COVER LETTER S51 ADVICE RESPONSE (MARCH 2023)

HyNet Carbon Dioxide Pipeline

Document Reference Number D.7.1.2

EN070007 HyNet Carbon Dioxide Pipeline – Further S51 Response

**EN070007-D.2.4-WP-Sheet 6**

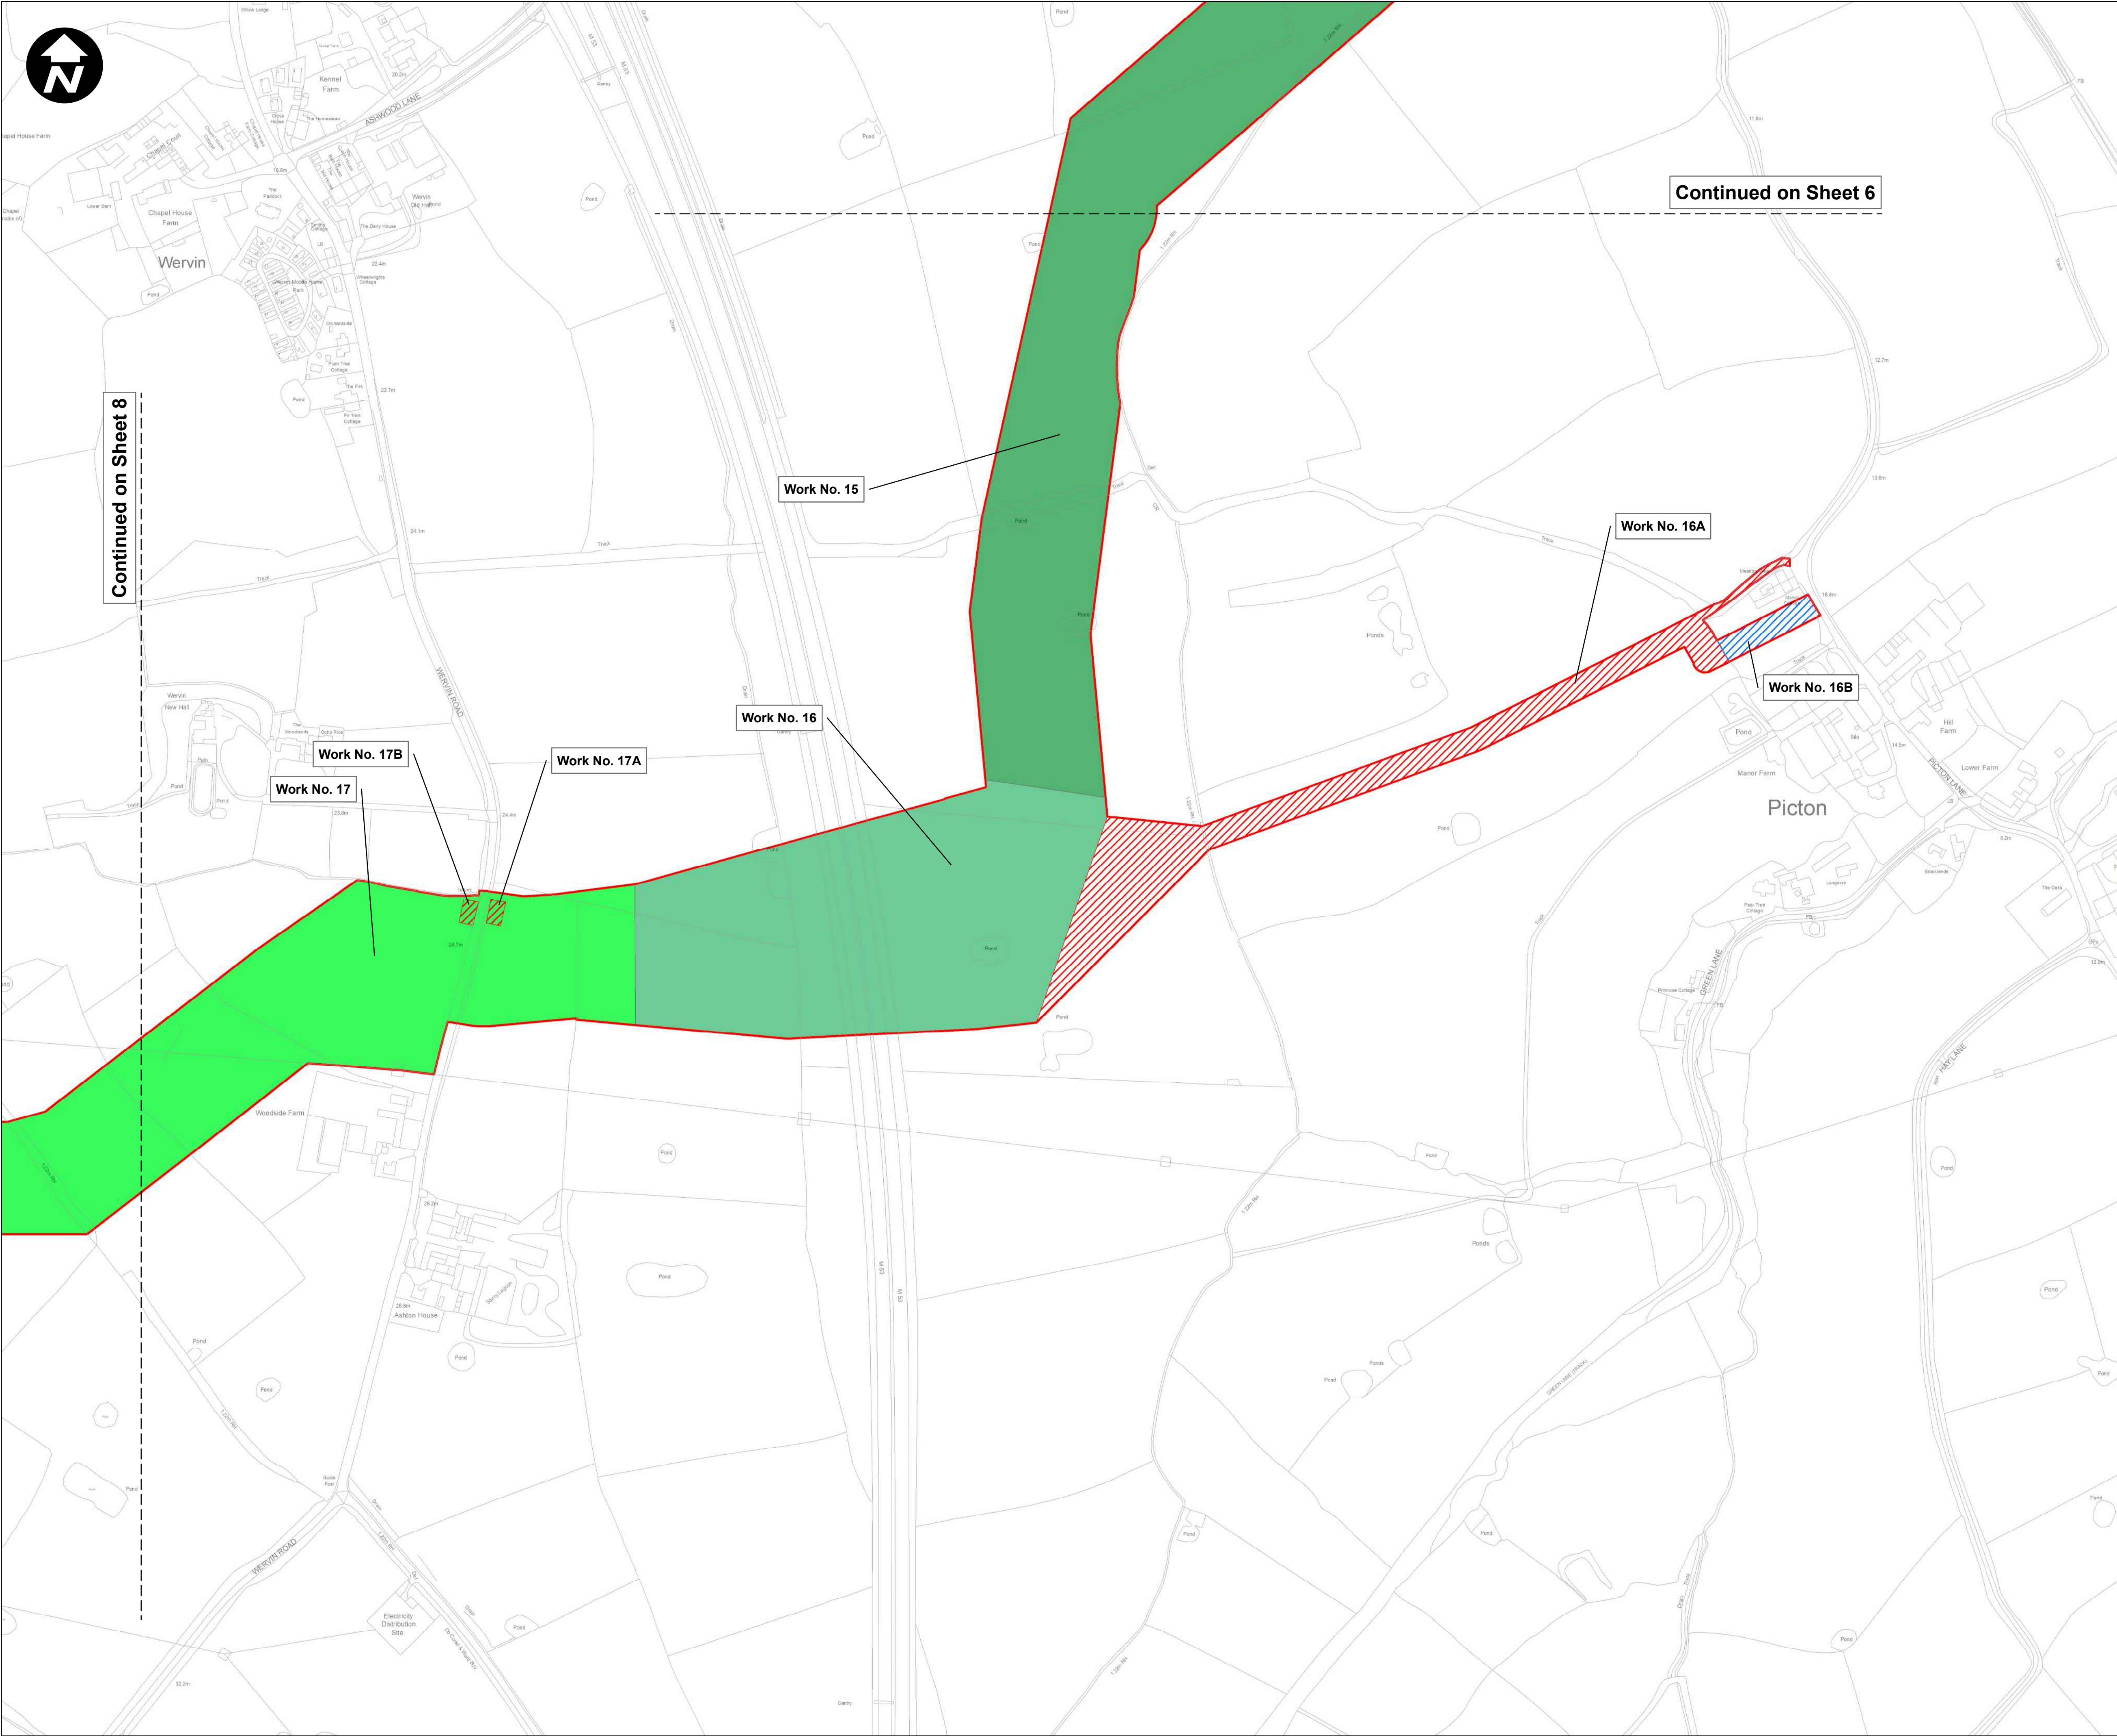
Application reference no.	Document Name	Sheet no.	Nature of Change	Reason For Change
APP-008	Land Plans	Sheet 1	Addition of label for plot 1-18	Post-Acceptance Errata
		Sheet 6	Addition of inset (2a) on sheet 6	Post-Acceptance Errata

**EN070007-D.2.4-WP-Sheet 7**

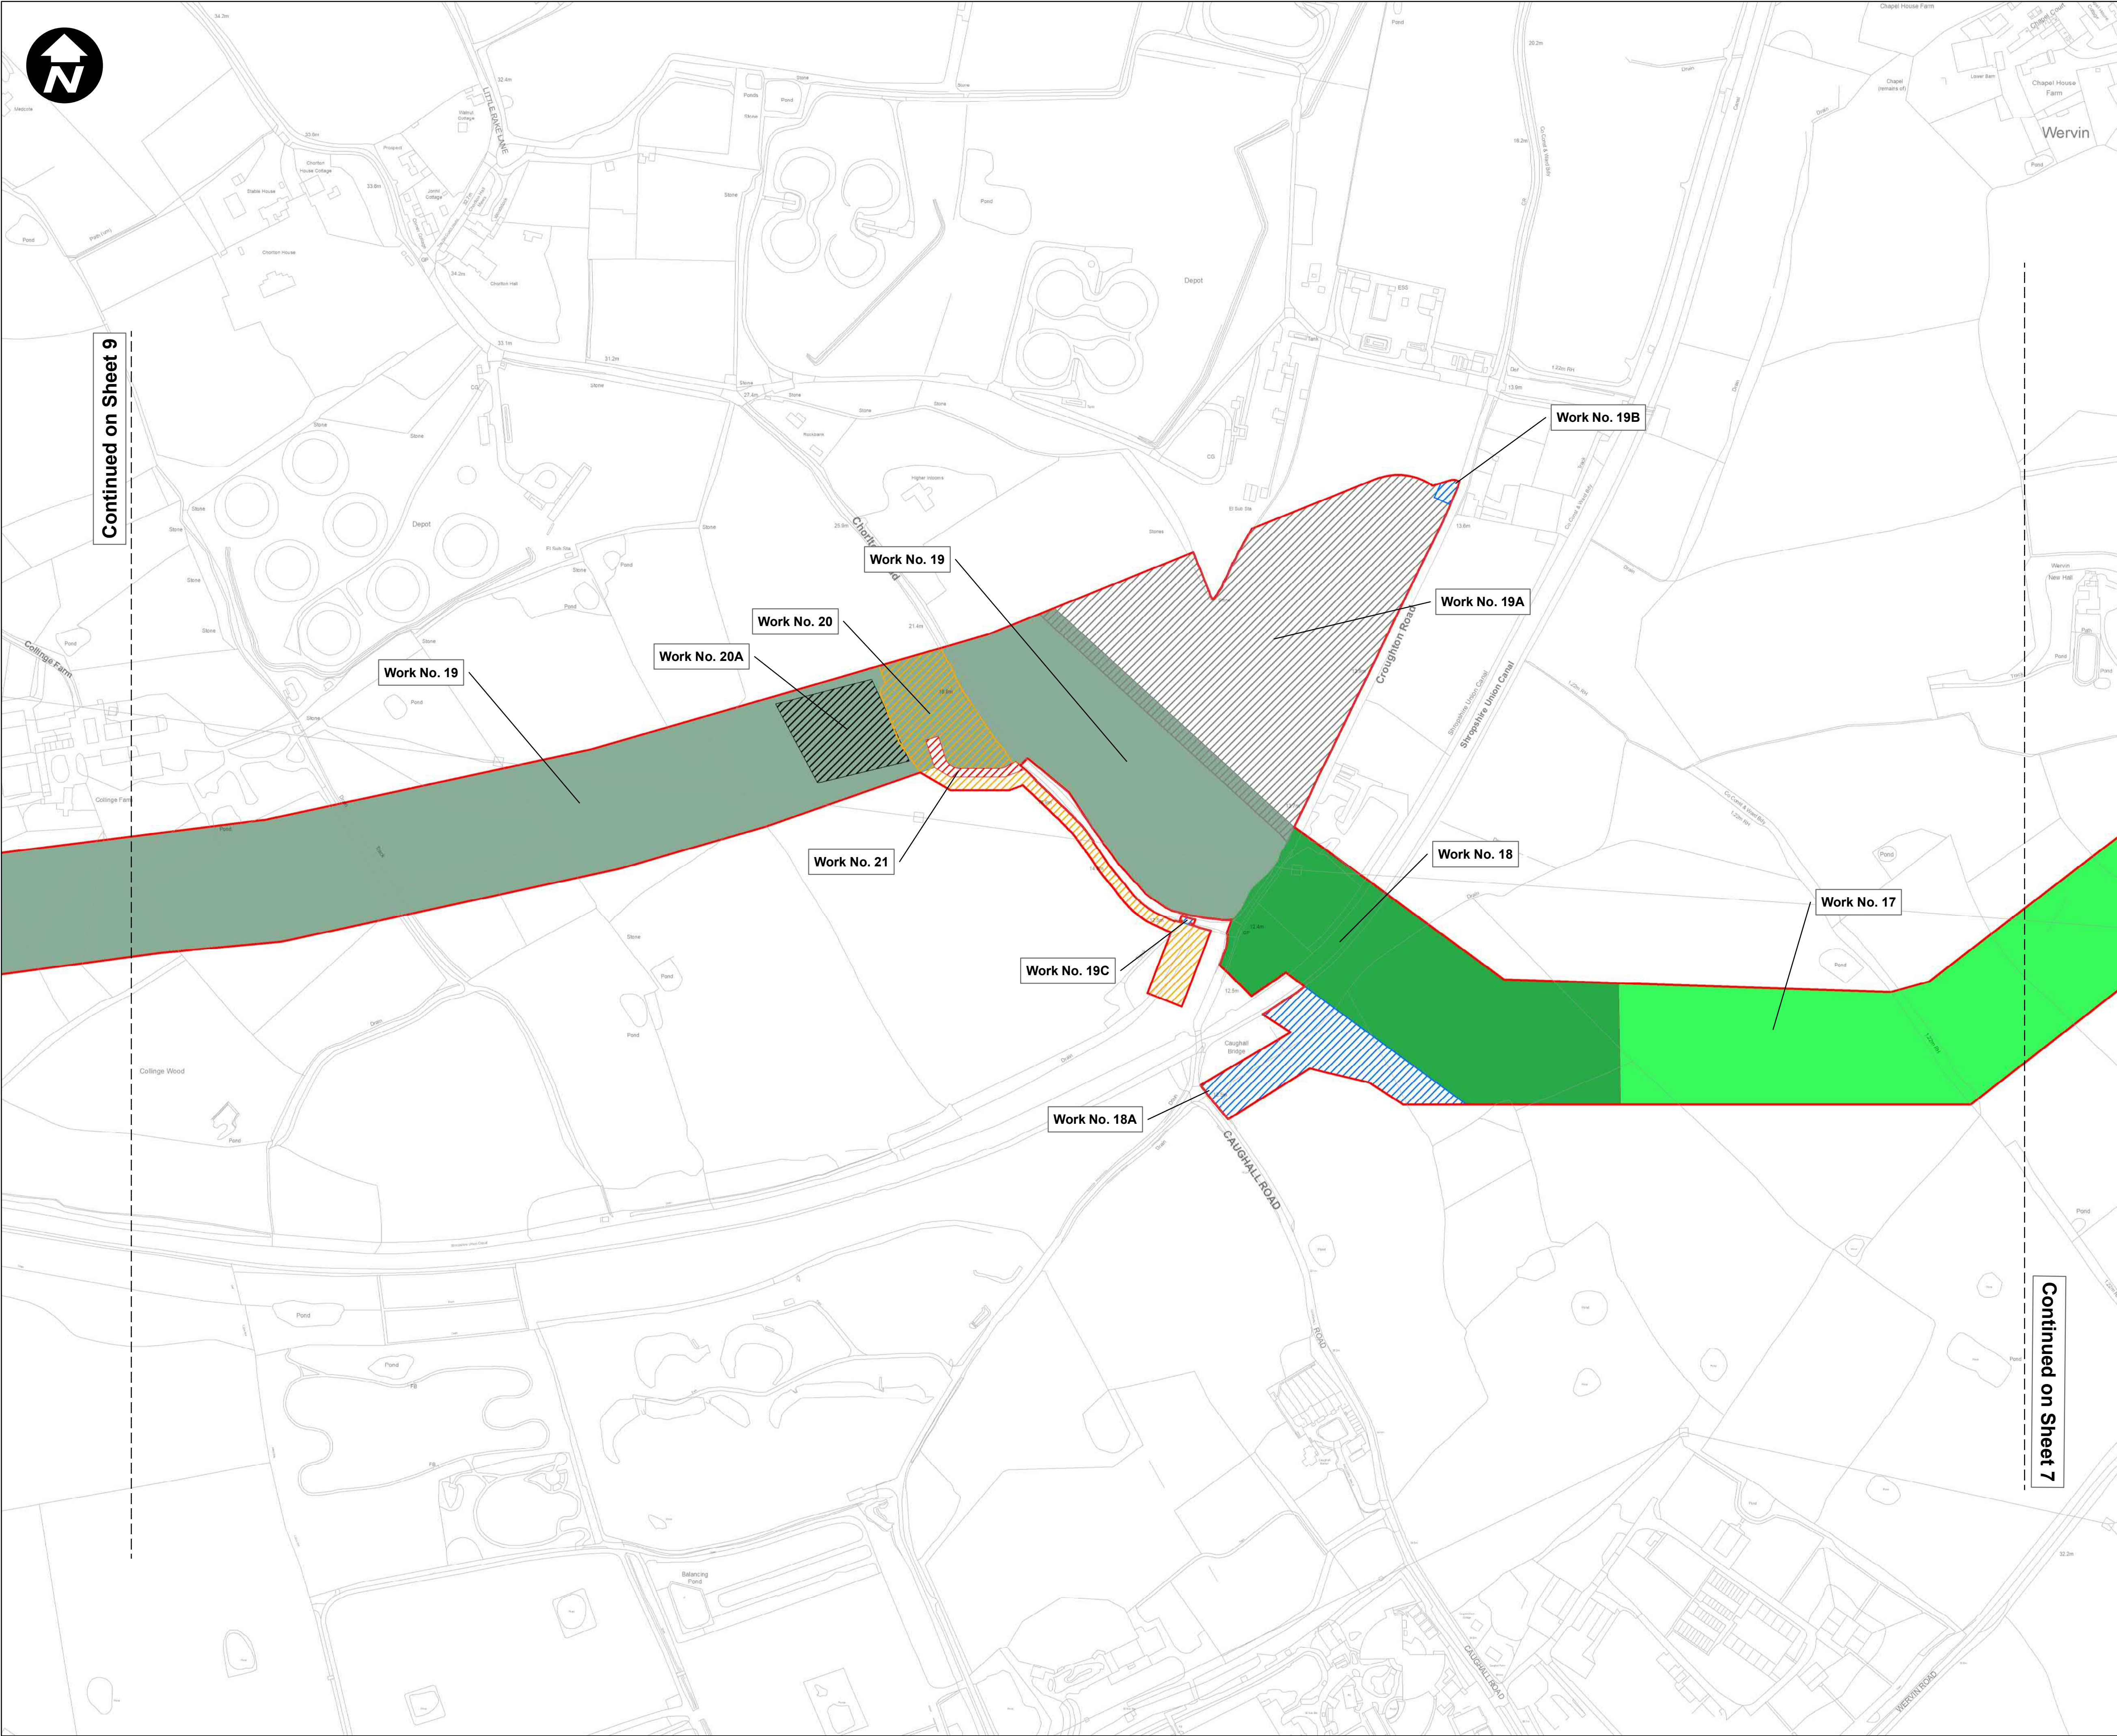
Application reference no.	Document Name	Sheet no.	Nature of Change	Reason For Change
		Sheet 7	Addition of Work No. 17A and 17B to highlight new permanent access points	Post-Acceptance Errata
		Sheet 8	Work No. 19C changed from Permanent Access to Temporary Access	Post-Acceptance Errata
		Sheet 9	Hatching for Work No. 24A reduced to fall within order limits to correct digitisation issue	Post-Acceptance Errata
		Sheet 10	Work No. 25A changed from Temporary Access to Permanent Access	Post-Acceptance Errata
		Sheet 10	Removal of white space to the north of Work No. 25 (sheet 10) by reducing the order limits to ensure that the property is not impacted by the DCO.	Post-Acceptance Errata
		Sheet 12	Addition of English/Welsh border in the key of sheet number 12.	Post-Acceptance Errata
